Subject: BE/137/19/RES The Cottage, Shripney Road

I have seen the objection of Bersted Parish Council to this application:

Swept Path Analysis

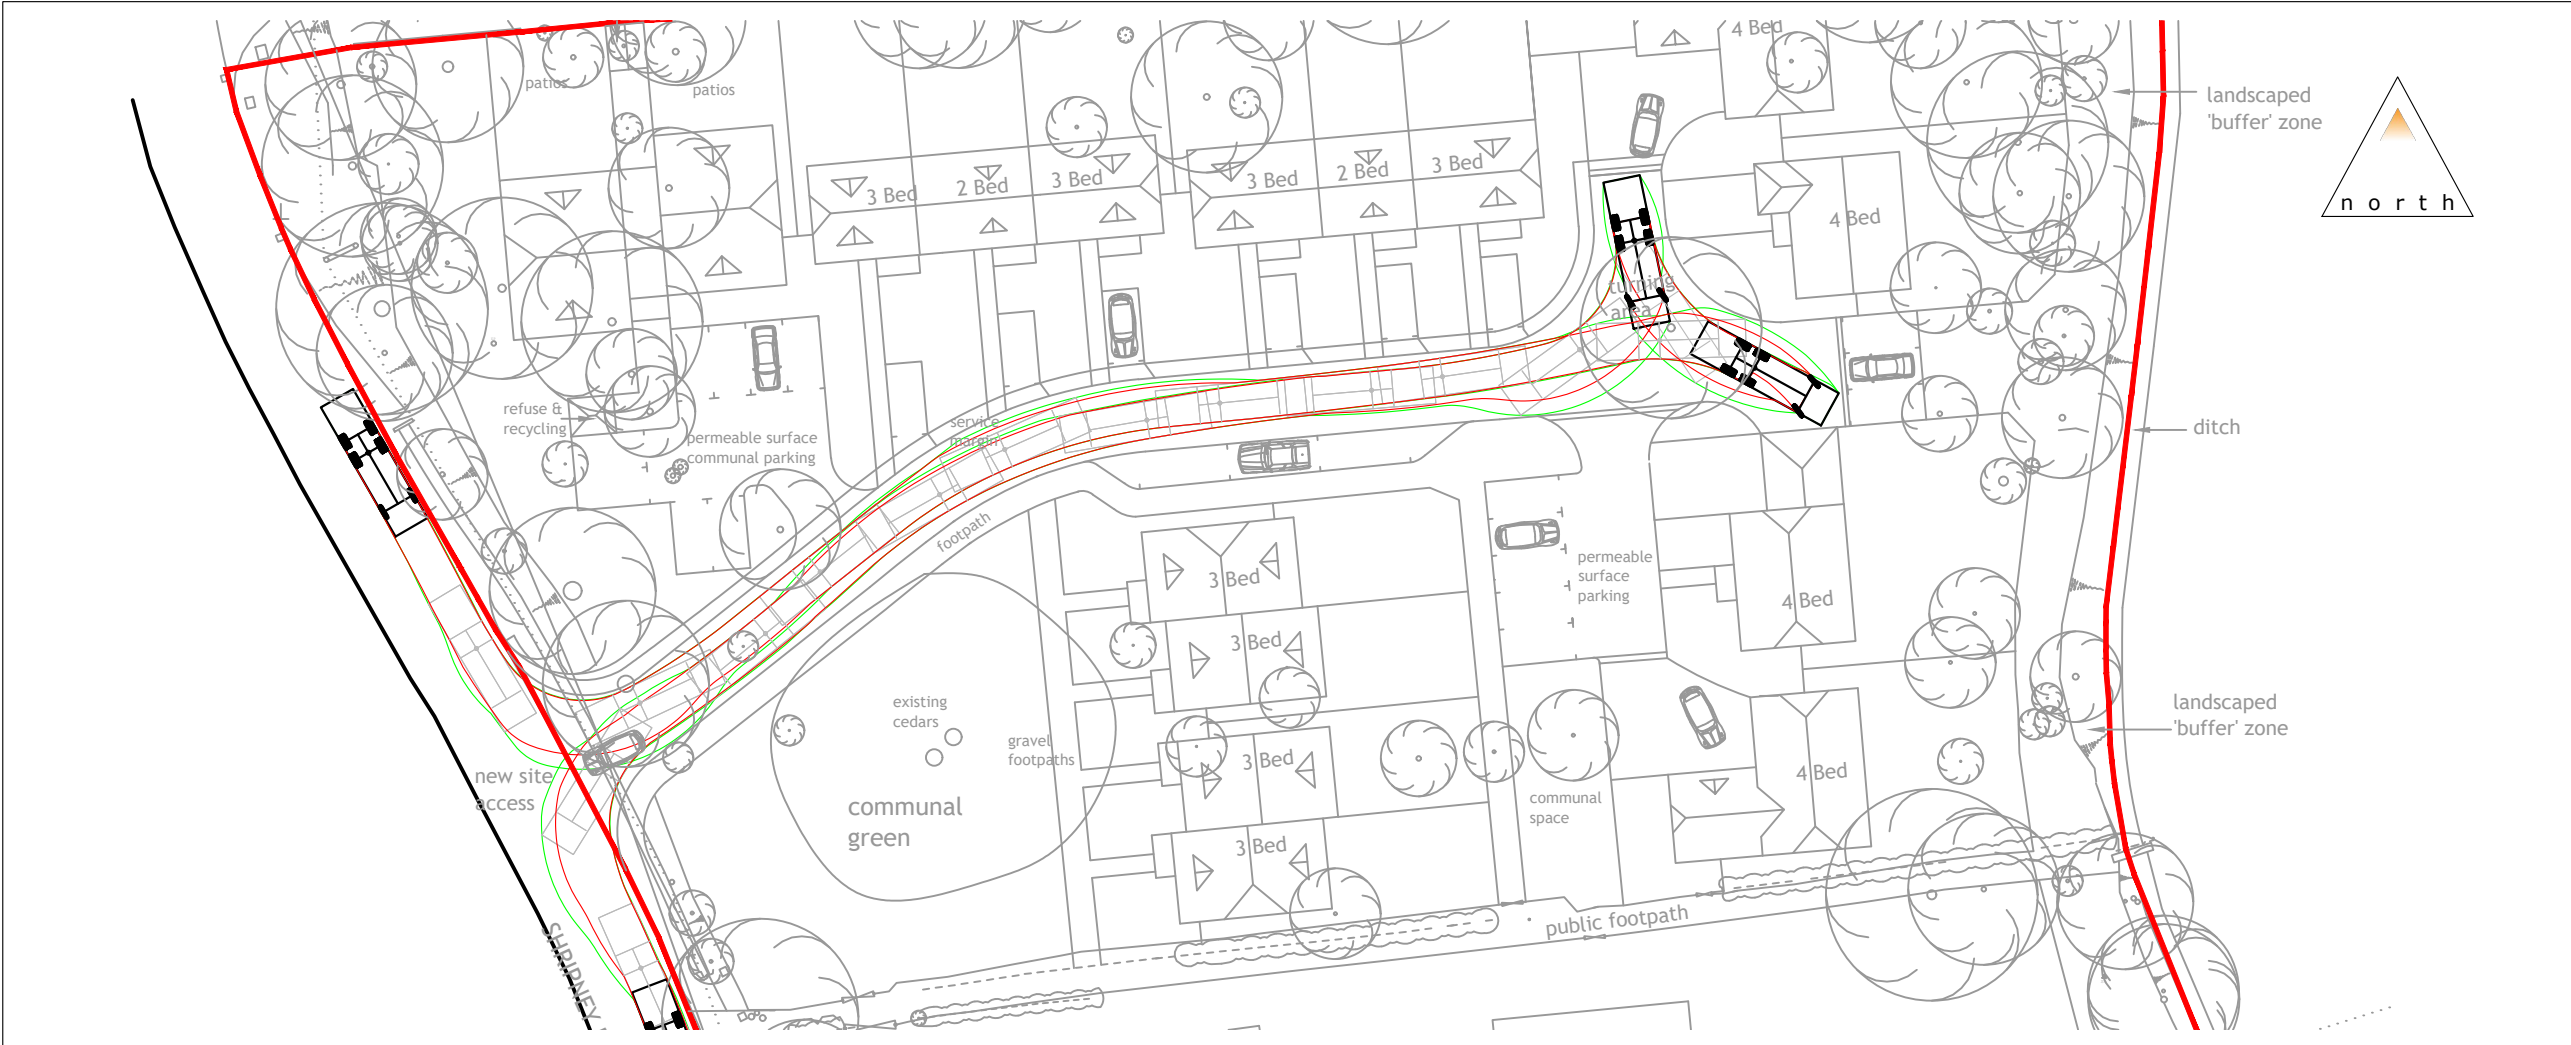
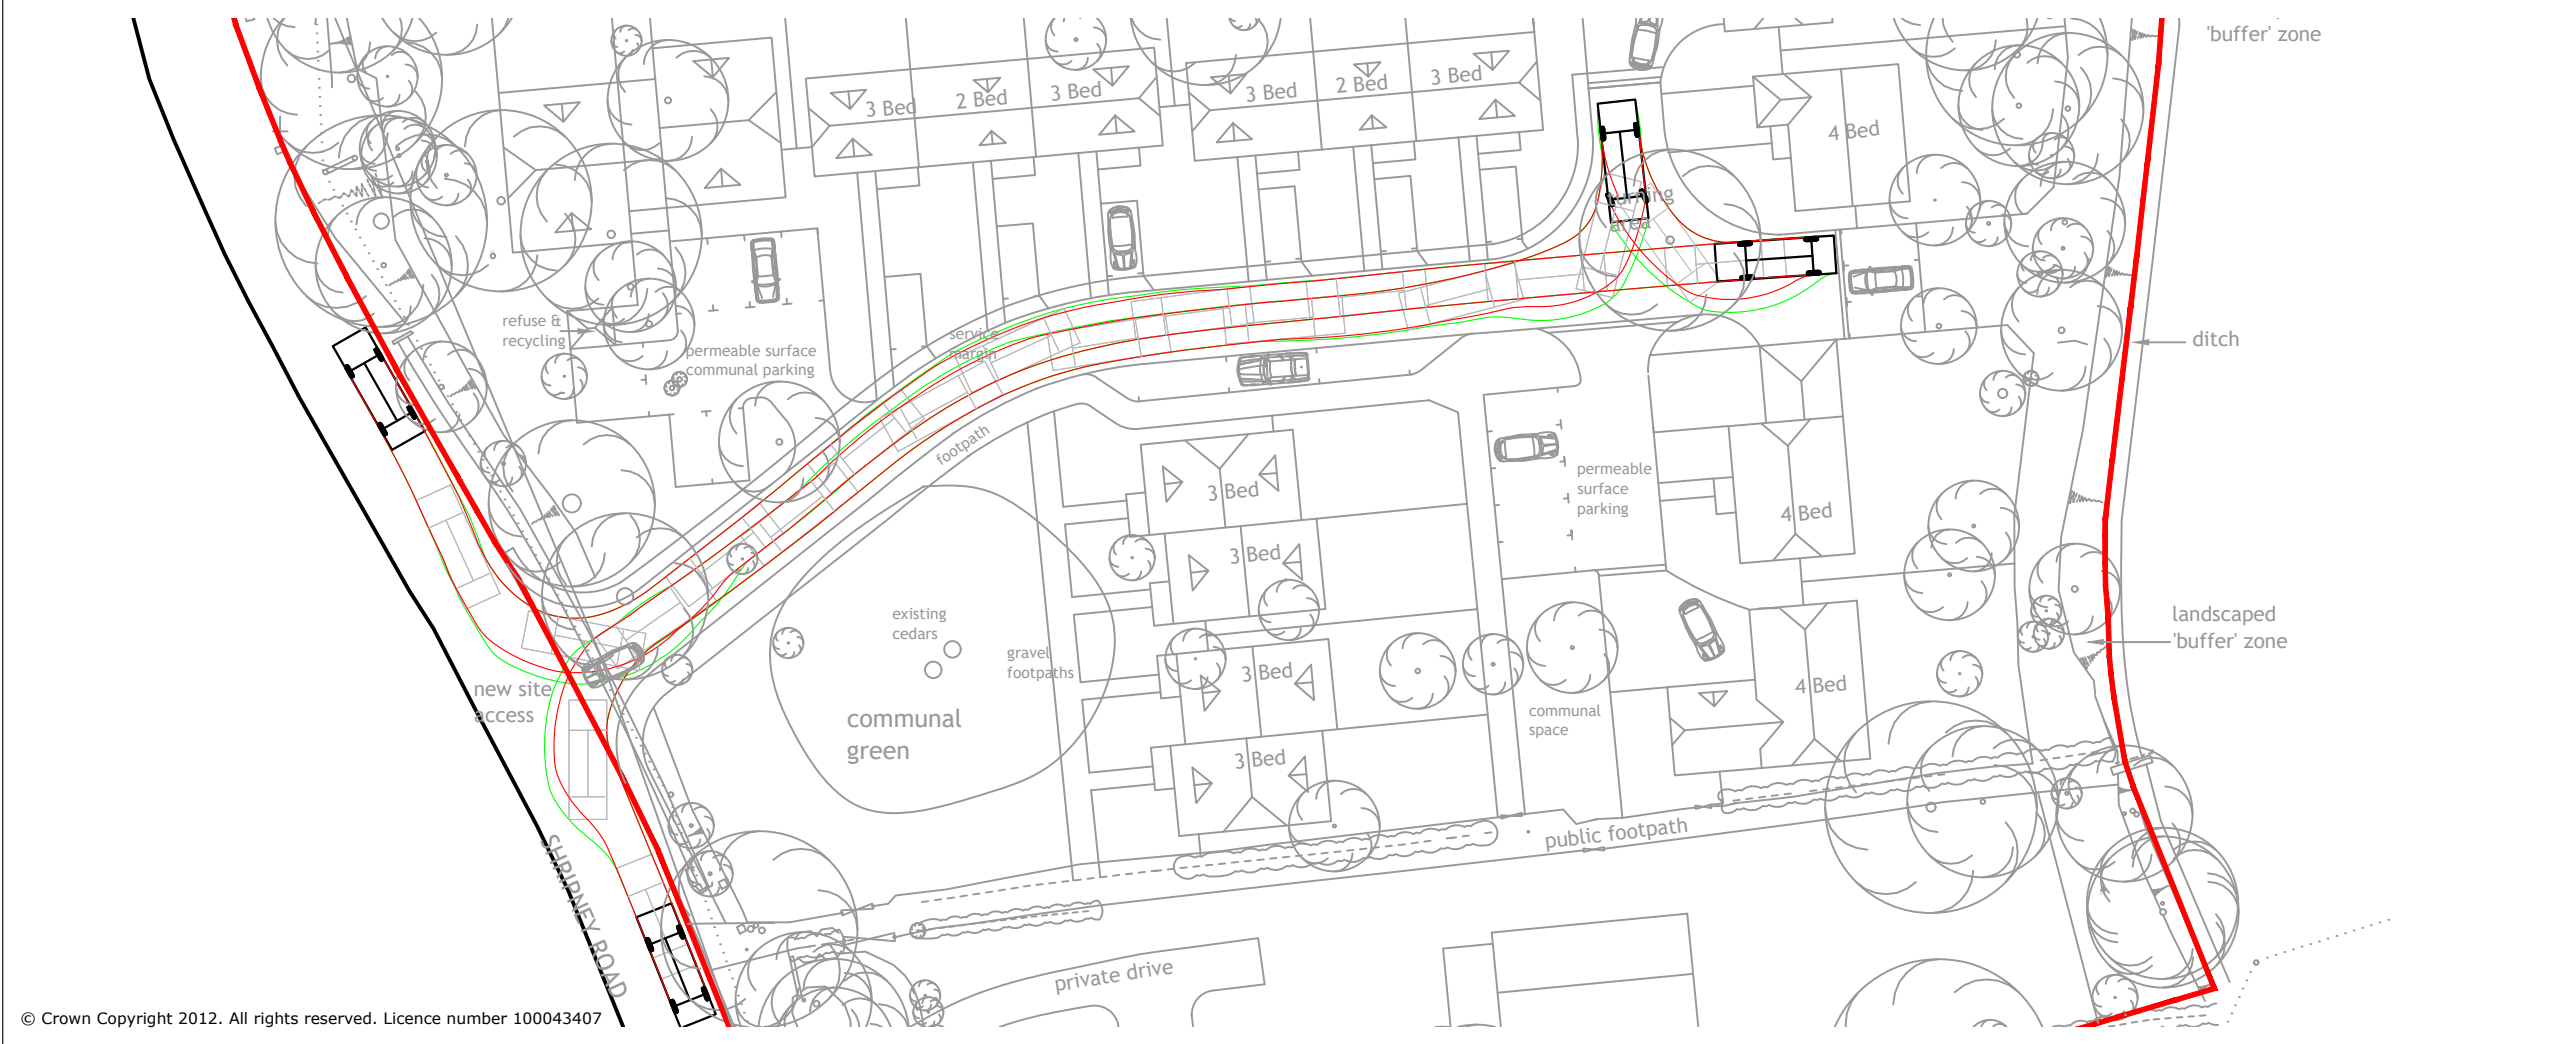
“Access & highway safety following WSCC Highways concerns that the width of the estate road is not considered wide enough making it difficult for refuse or emergency vehicles to turn safely in the development, without backing onto the A29. Arun Local Plan Policy T SP1 Transport and development. The design does not incorporate any facilities for charging electrical and plug in hybrid vehicles. Also it does not give priority to pedestrian and cycle movements and have access to high quality public transport facilities. The bus route through Shripney is every 3 to 4 hours and none on a Sunday. No consideration has been given for creating a safe cycle route along the A29 to service the development. Bersted Neighbourhood Plan Policy HDQ2 Integration of new housing. The development incorporates 2 storey dwellings these do not connect visually or integrate with the surrounding dwellings.”

- The applicant has provided a revised plan to widen the block paving turning head to 4.8m to enable a refuse vehicle to turn more comfortably;
- On the same plan, they now show EV charge points according to our standards;
- Matters relating to the location and sustainability of the site and public transport improvements were considered at the outline stage. We cannot on this Reserved Matters application, request public transport/pedestrian cycle improvements as we are only able to consider design, scale, layout of the site and landscaping.
- There are 2 storey buildings on the opposite side of the road and also on the Robin Hood site. If you meant to say 2.5 storeys then I will understand this point better.
